Our Ref: SDNP/22/01442/ADJAUT

Neighbouring Authority Consultation

**Proposal: Adjoining Authority Consultation - Arun District Council (A/41/22/DOC) -
Approval of details reserved by condition imposed under ref A/40/18/OUT relating to
Condition No 5 - design code masterplan.**

Address: Land North of Water Lane , Angmering , BN16 4EU,

Pedestrian & cyclist movement network diagram ►

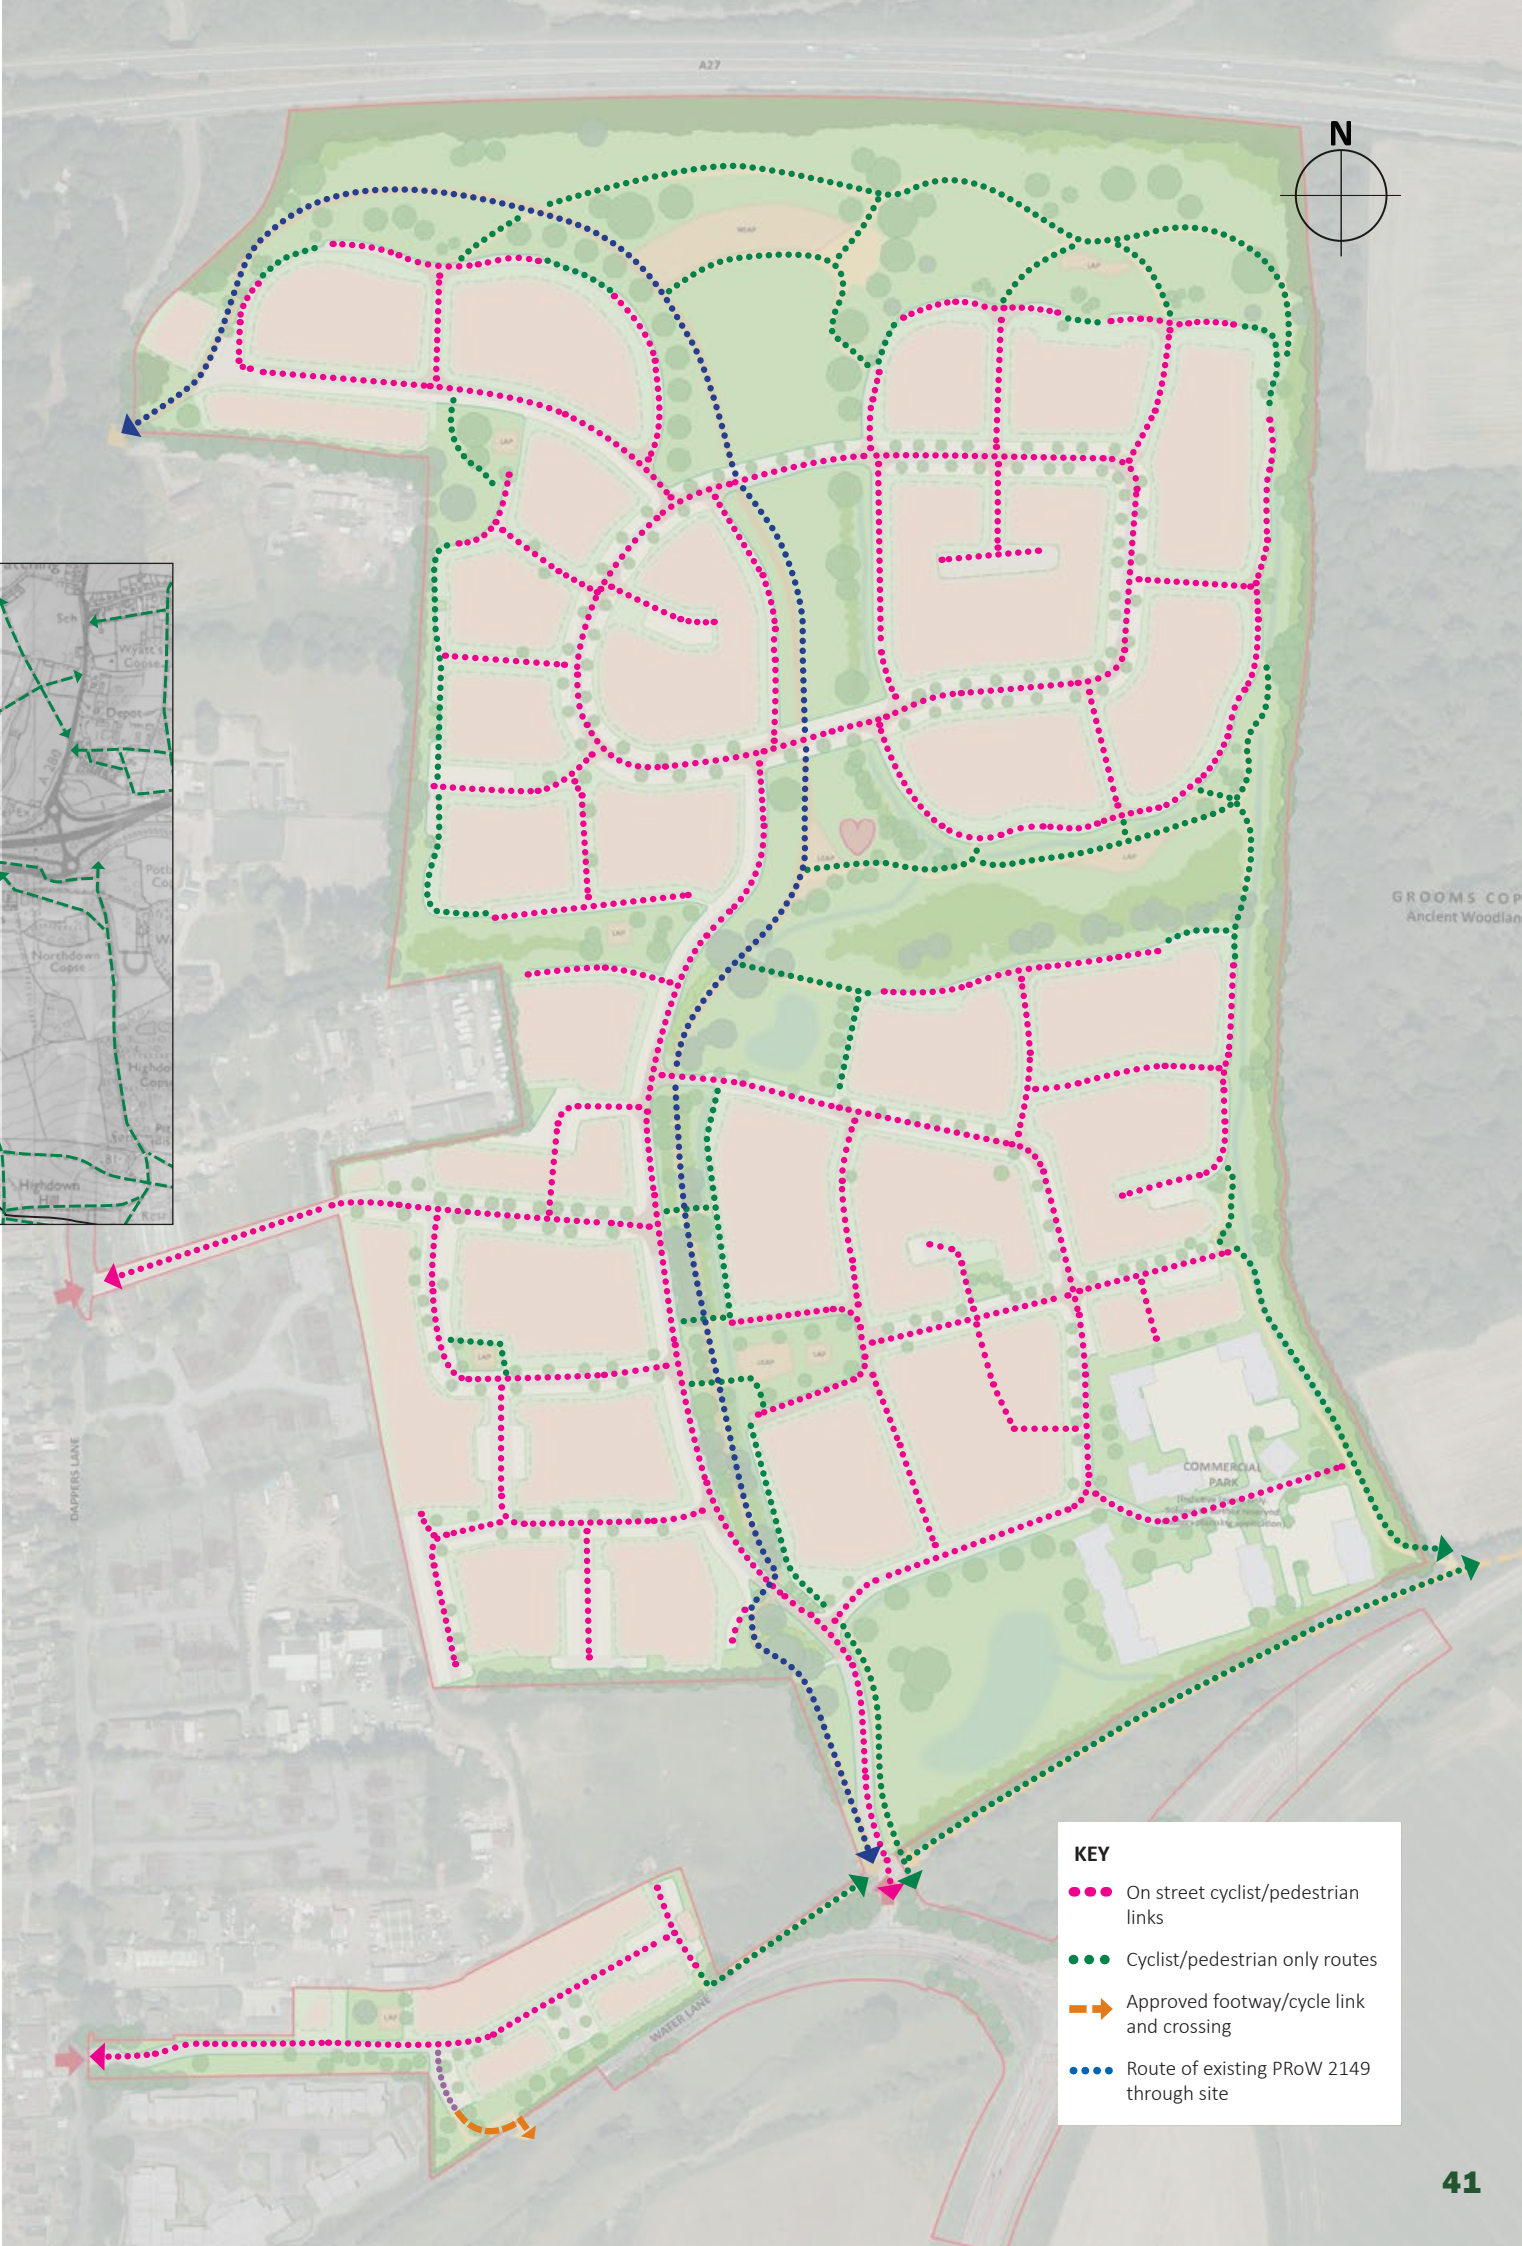
The upgrading of the existing right of way passing through the site to a 3m wide pedestrian/cycleway. This is the minimum recommended width for a shared cycleway, but the principle is welcomed as it will improve access for pedestrians/cyclists to Dappers Lane and the National Park beyond.

It should be noted that Page 41 of the submitted Design Code document is incorrect in referring to this being along the route of the existing PRow 2149 as the expansion of the developed area to the north would result in a more circuitous realignment of this route.

5.3 The Village Character Area

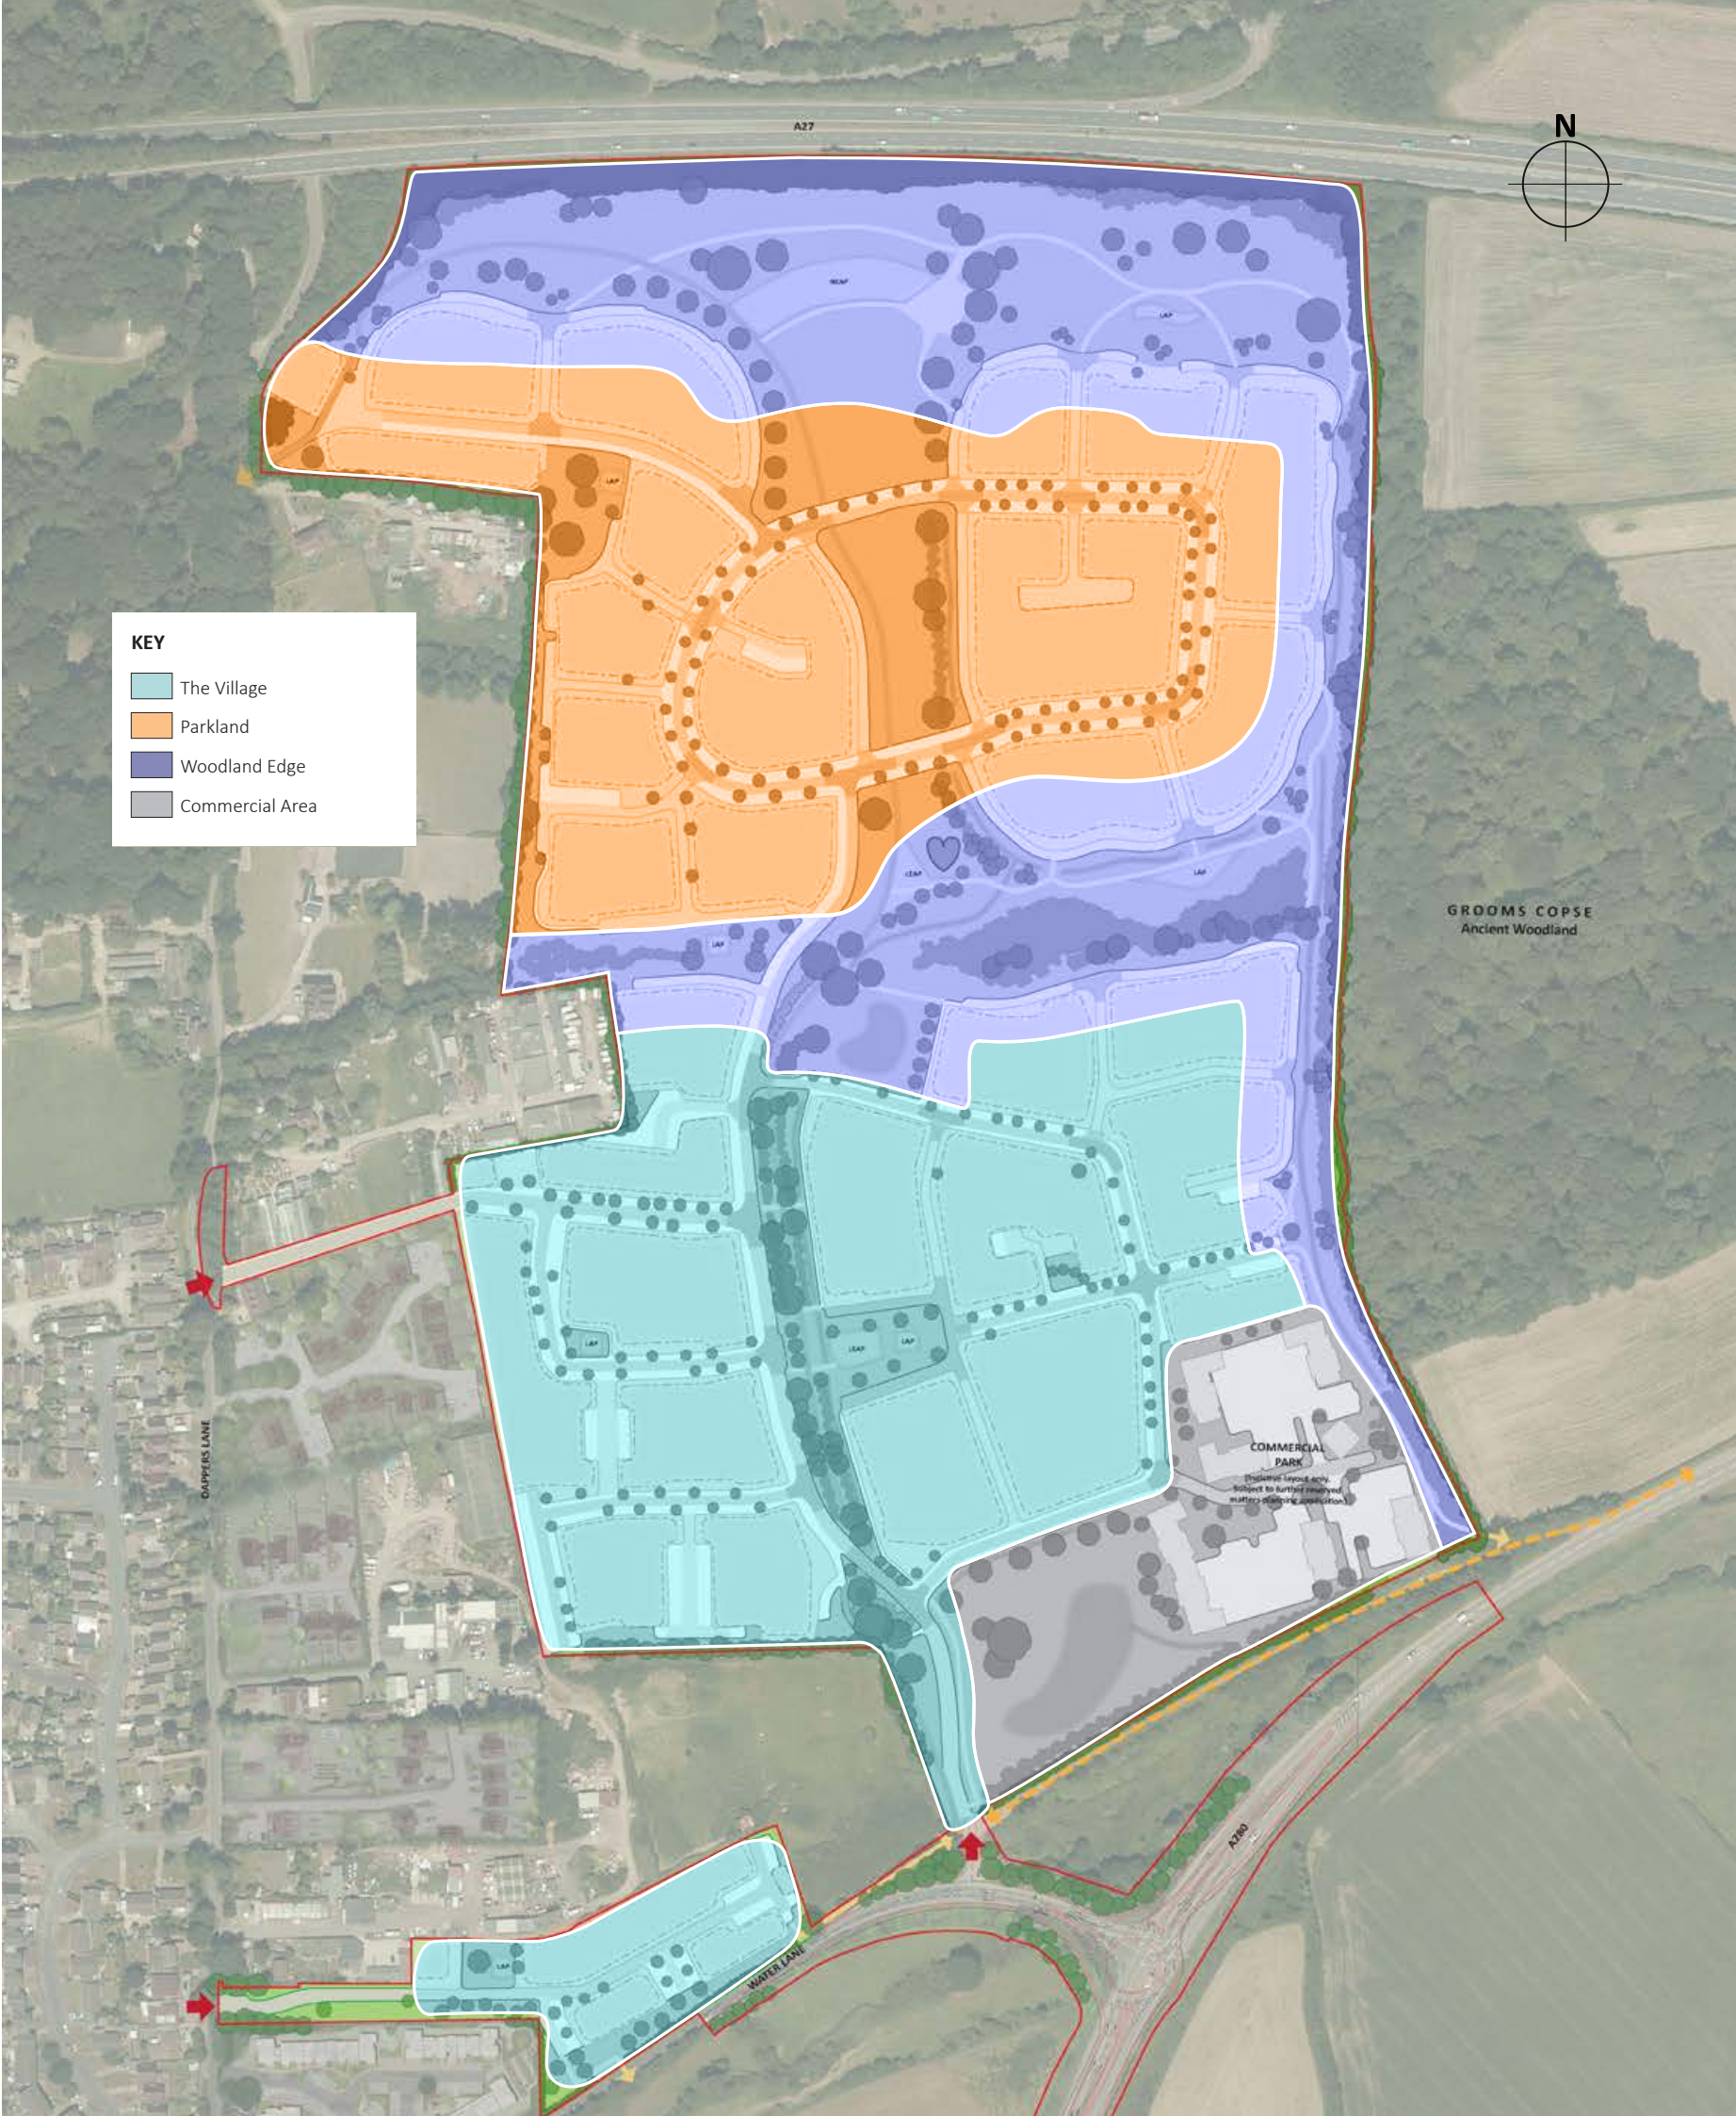
With regard to the proposed character areas, the concept of the "Woodland Edge" character area is welcomed. However, it is noted that the "Village" character area appears to contain more tall buildings (2.5 storeys) than indicated in the building heights parameter plan originally approved.
